**WEST SUSSEX COUNTY COUNCIL
PLANNING SERVICES CONSULTATION**

SUBJECT: LU/278/17/RES - Approval of Reserved Matters following Outline Permission LU/47/11 for Construction of the southern section of the Lyminster Bypass, including northern and southern roundabouts, surface water drainage and landscaping. Departure from the Development Plan and affects a Public Right of Way.

LOCATION: North Littlehampton Strategic Development Site, Land West of Toddington Park, Toddington Lane, Littlehampton, BN17 7PP.

This is the second WSCC highways and transport response to the planning application for approval of reserved matters following Outline Permission LU/47/11 for Construction of the southern section of the Lyminster Bypass, including northern and southern roundabouts, surface water drainage and landscaping.

- Groundcover: dwarf mountain pine.
Refer to drawing SLB 2 for plant
schedule
- Pine tree
Refer to drawing SLB 2 for plant
schedule
- Gravel area
- Timber edging board
- Drainage features
- Visibility splays

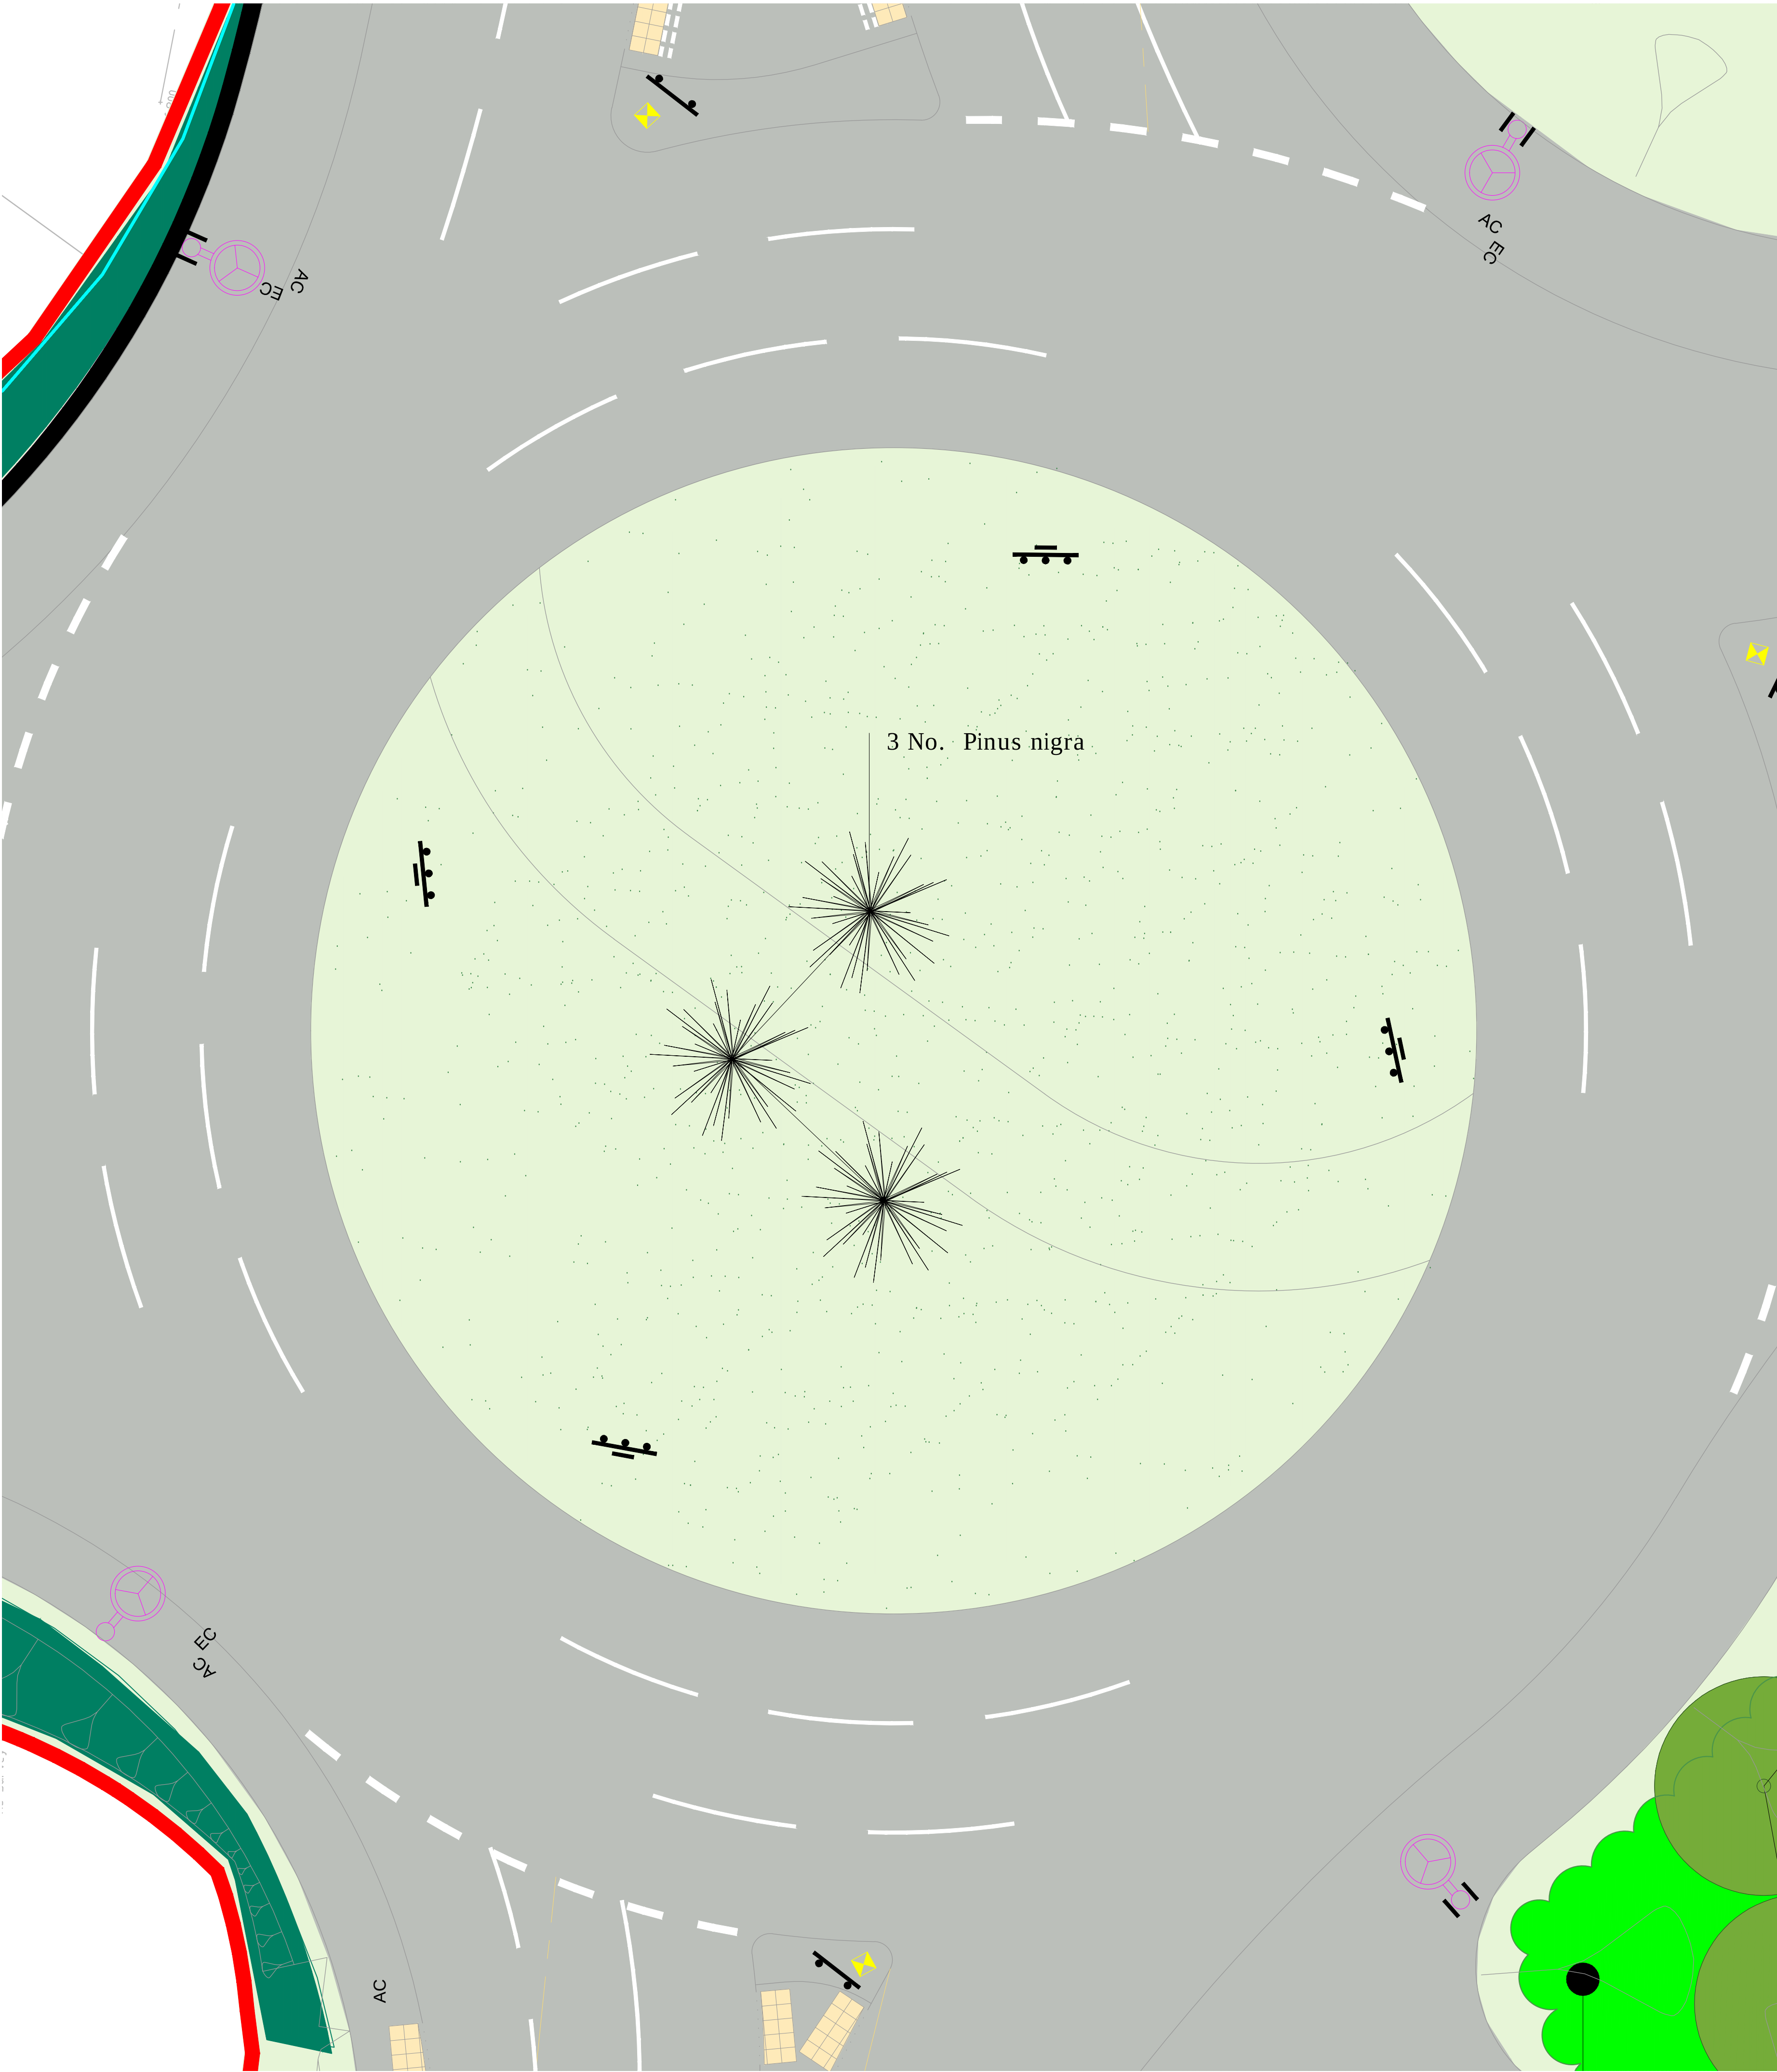
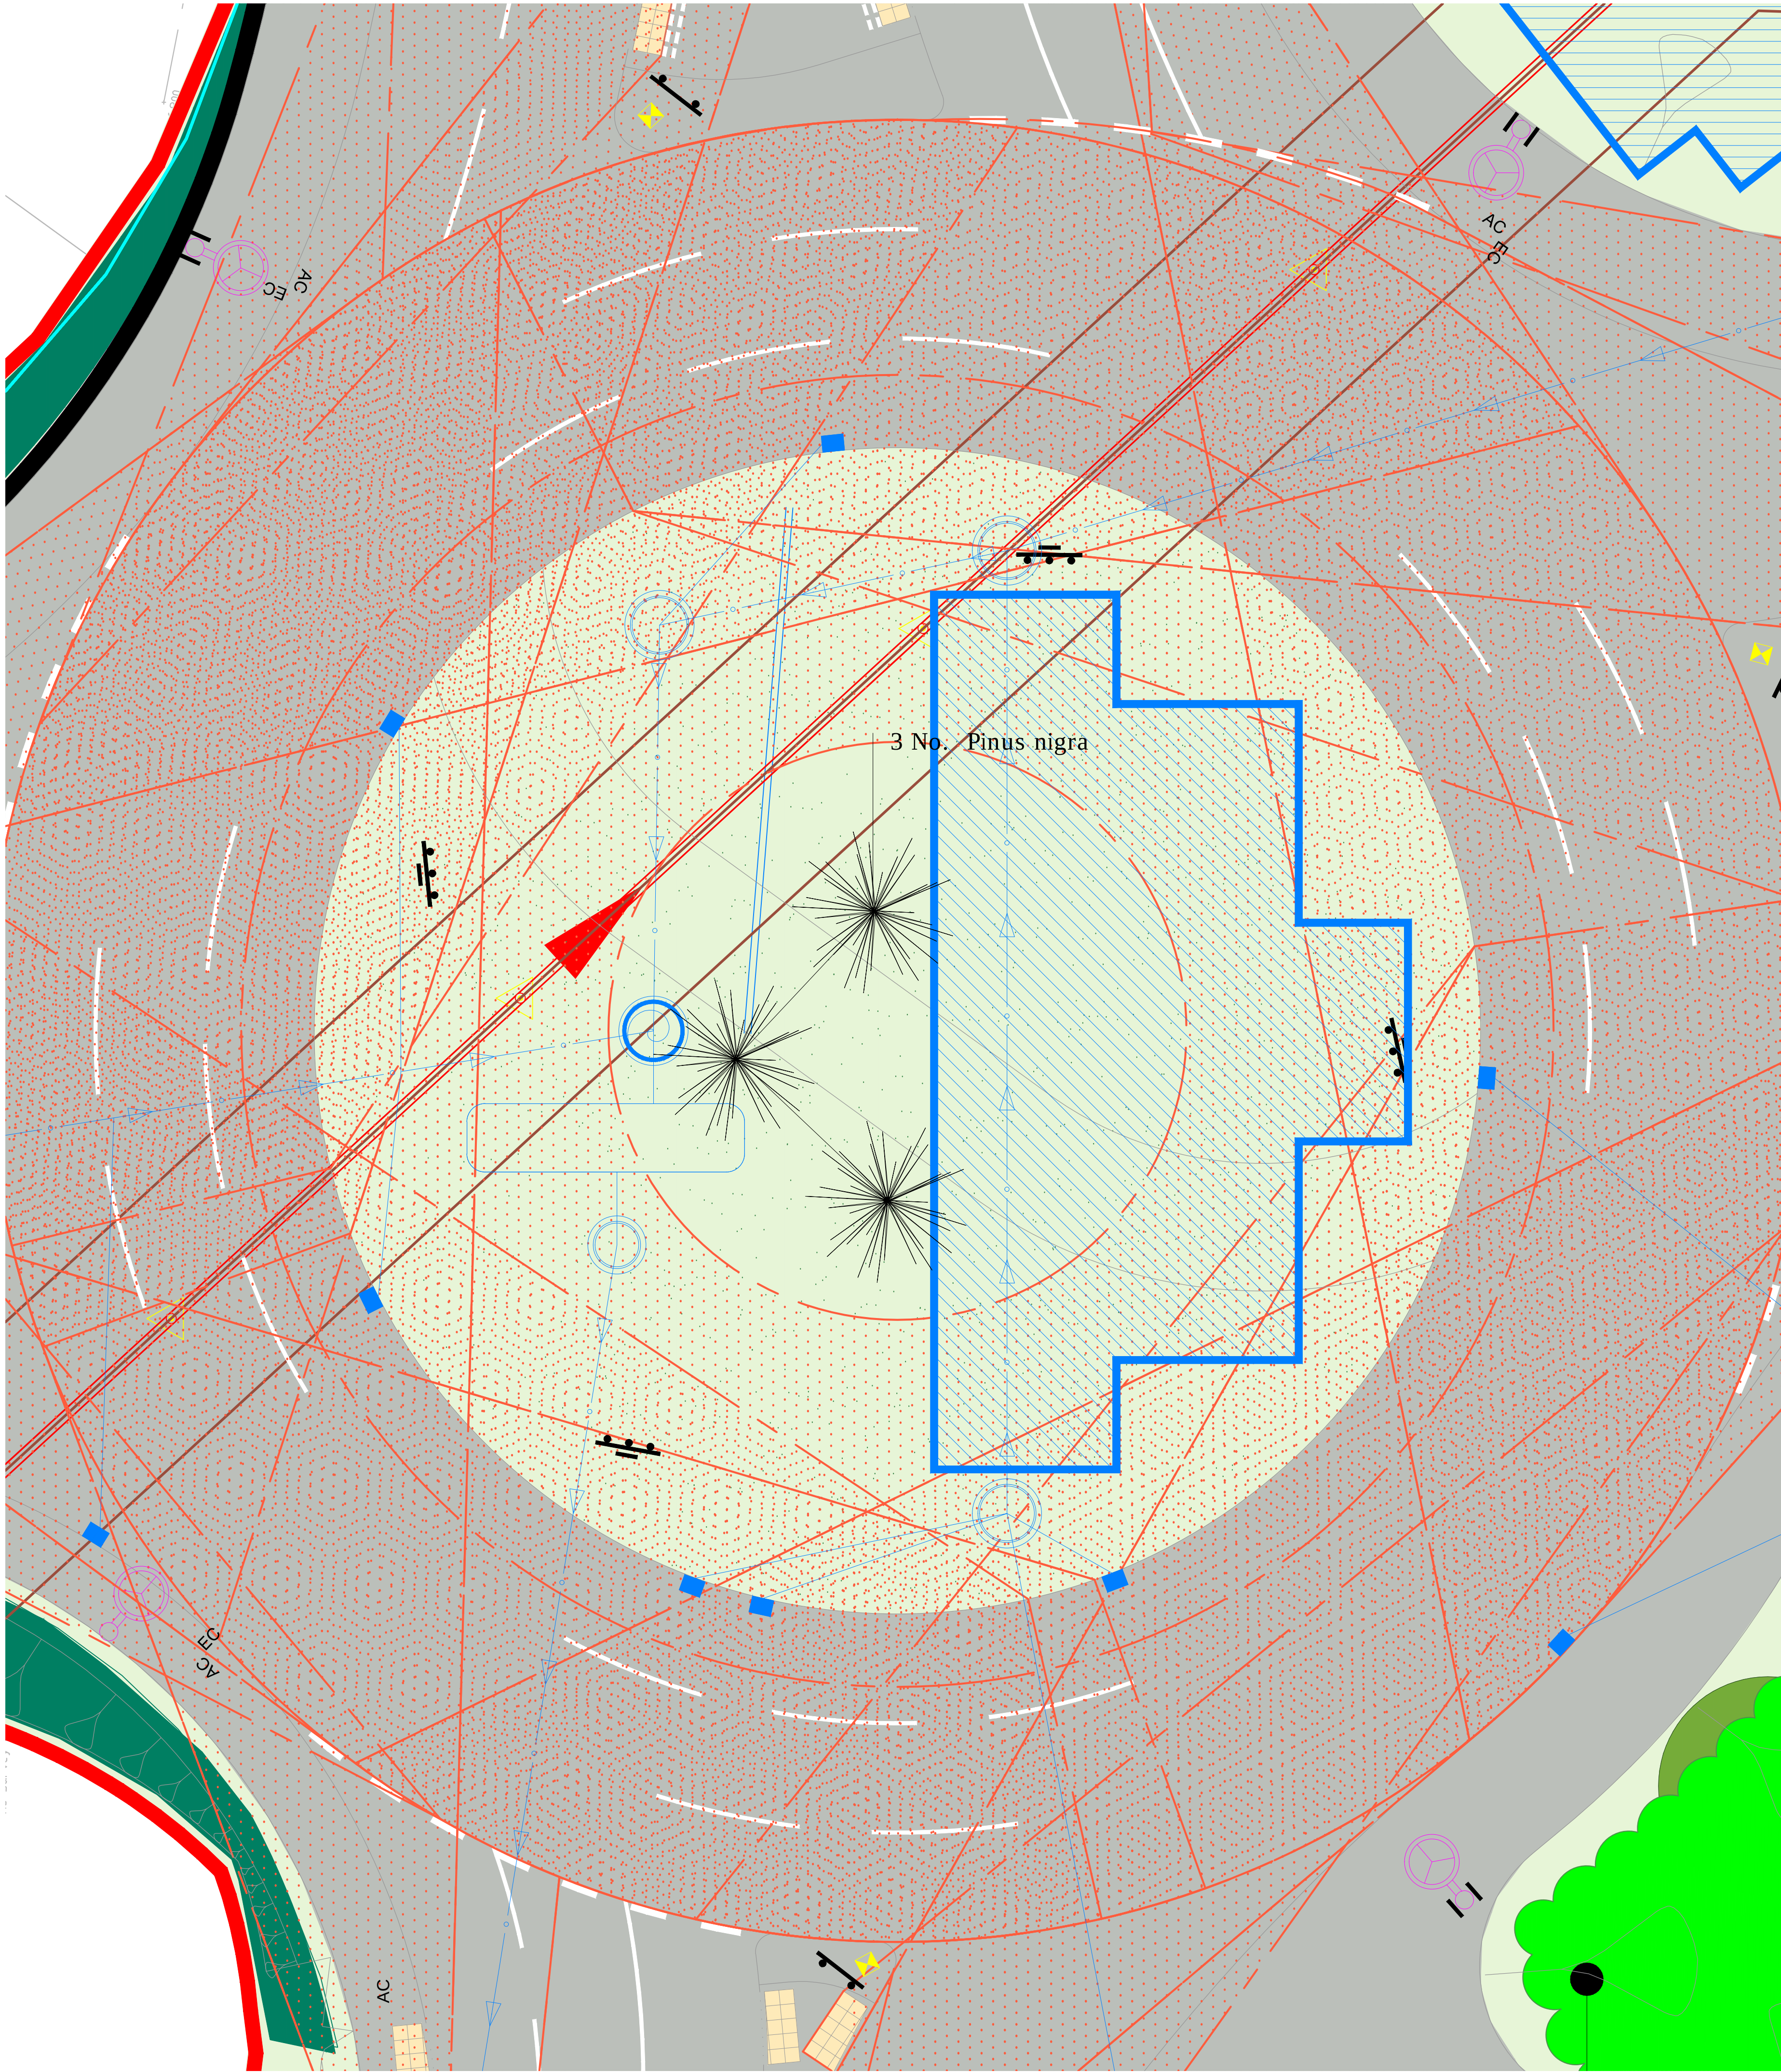
Earlier versions of these drawings had no indication what revision they were. Applicant to confirm final versions.

Comments had also been made previously about having no planting on the cellular storage areas, other than grass. The applicant now appears to have revised this accordingly.

Timber features and ground-cover ivy have been removed from both roundabouts.

For the **Northern roundabout** the underground storage tank has been removed. Pine trees and ground-cover pine are proposed within the centre of the roundabout (outside the visibility splays). For the **Southern roundabout**, the storage tank remains. Pine trees are again proposed within the centre of the roundabout. **Drainage comments to follow separately.**

Regarding planting, the CHA had stated that thorny planting (blackthorn [Prunus spinosa], or otherwise) should not be planted adjacent to or close to cycle paths. The applicant has noted and amended this - Thorny shrubs (Ilex aquifolium, Prunus spinosa, Rosa canina and Crataegus monogyna) have been removed. Sambucus nigra and Salix caprea have been added to the mix. It is not known whether what is proposed will be in the form of individual shrubs or designed/planted as a hedge. This should be made clear before determination of the proposal in order to understand maintenance regime etc.

Owl boxes (and the barn owl box), previously shown too close to road have now been shown removed and re-located.
